MORGAN AND MORECAMBE OFFSHORE WIND FARMS: TRANSMISSION ASSETS

Applicants' Response to Deadline 5 submissions from Statutory Consultees and other organisations

Document Reference: S_D6_2
F01

22 October 2025

Figure 1.16a: Defended 1% AEP fluvial event plus 20% climate change uplift

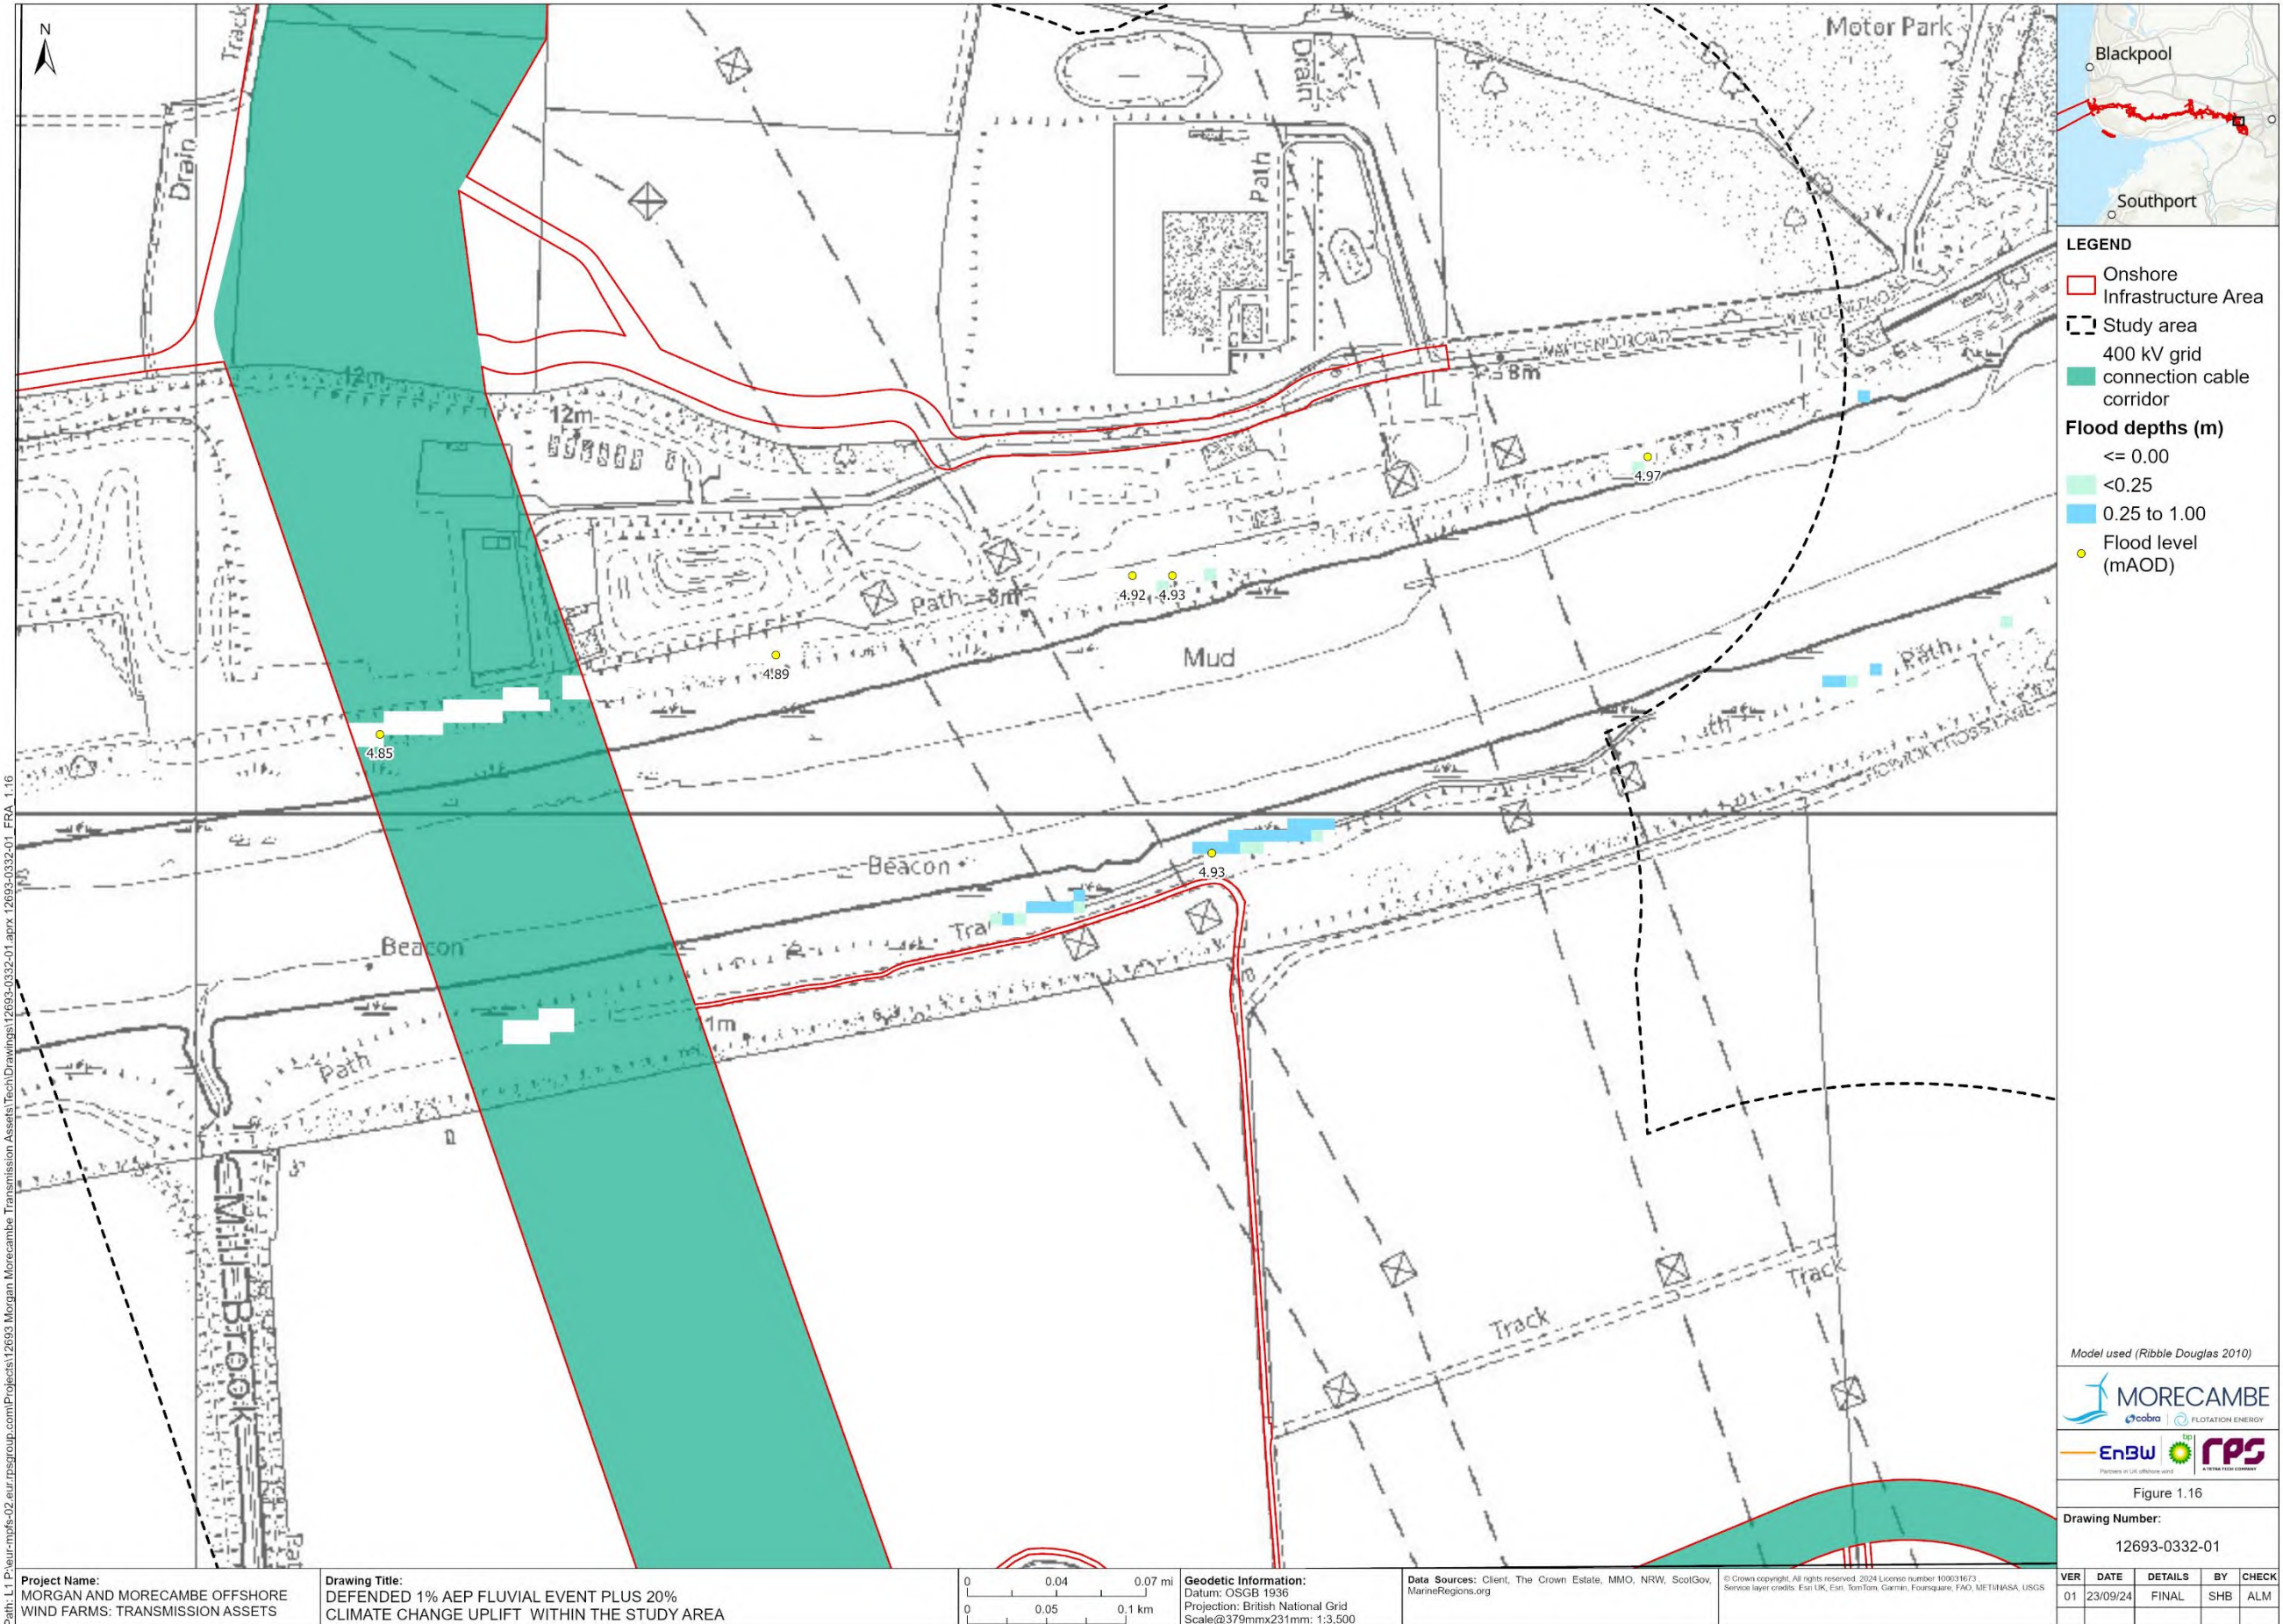
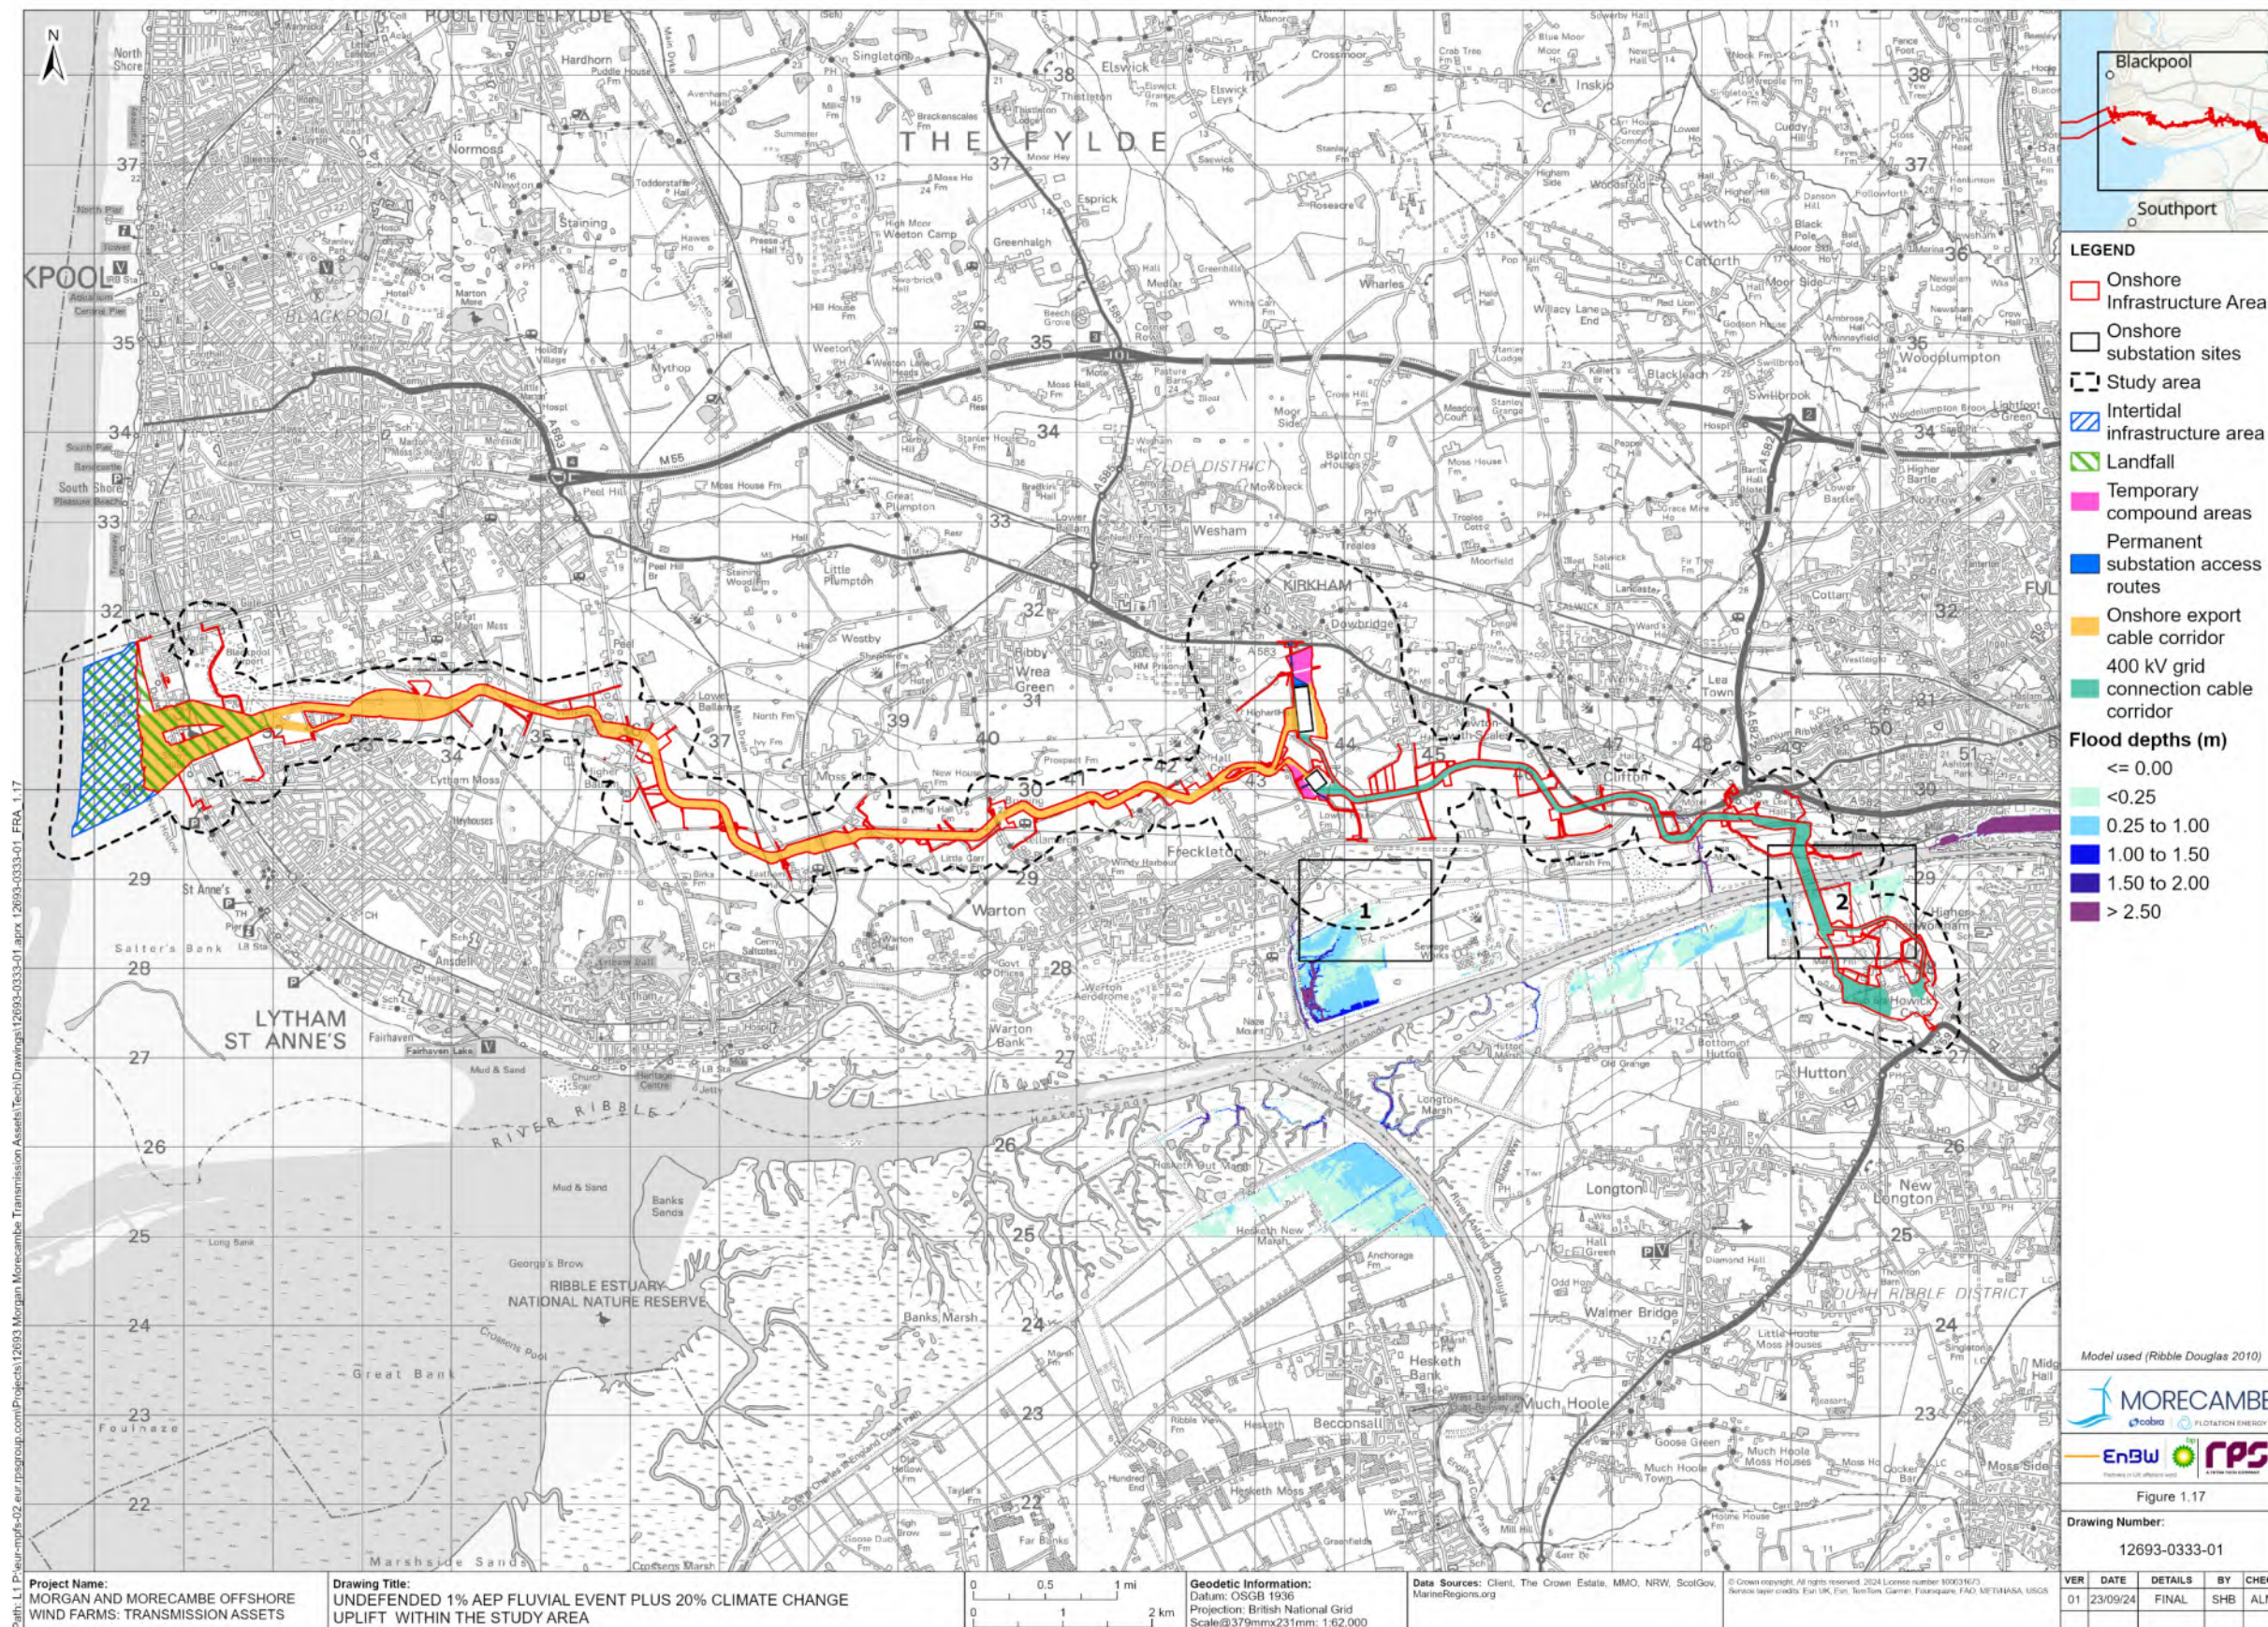
REP5-168	<p>Volume 3, Annex 2.3: Flood risk assessment - part 2</p>	<p>The Applicants note this comment and confirm that the discrepancy only appeared on the tracked version and therefore, no changes were required. The</p>

Reference	IP submission	Applicants' response
168.9	<p>Pages 163- 166</p> <p>Issue: Changing in titles and figure numbers appears to have resulted in a discrepancy between the new figure label in the report and the figure reference in the original title box of the drawing.</p> <p>Impact: This makes references somewhat problematic and confusing.</p> <p>Solution: Clerical error requiring correction</p>	<p>Applicants have ensured that all figure references and numbers are consistent. An updated version of volume 3, Annex 2.3: Flood risk assessment (F3.2.3/F03) has been submitted at Deadline 6.</p>
REP5-168 168.10	<p>Volume 3, Annex 2.3: Flood risk assessment part 3</p> <p>Issue: Like previous comments.</p> <p>Changing in titles and figure numbers appears to have resulted in a discrepancy between the new figure label in the report and the figure reference in the original title box of the drawing.</p> <p>e.g. Figure 1.23: Undefended 1% AEP fluvial event plus 20% climate change uplift on Page 199 is figure 1.17 in the drawing title box.</p> <p>Impact: This makes referencing somewhat problematic and confusing.</p> <p>Solution: Clerical error requiring correction</p>	<p>The Applicants note this comment and have updated all figure references and numbers where appropriate. An updated version of volume 3, Annex 2.3: Flood risk assessment (F3.2.3/F03) has been submitted at Deadline 6.</p>
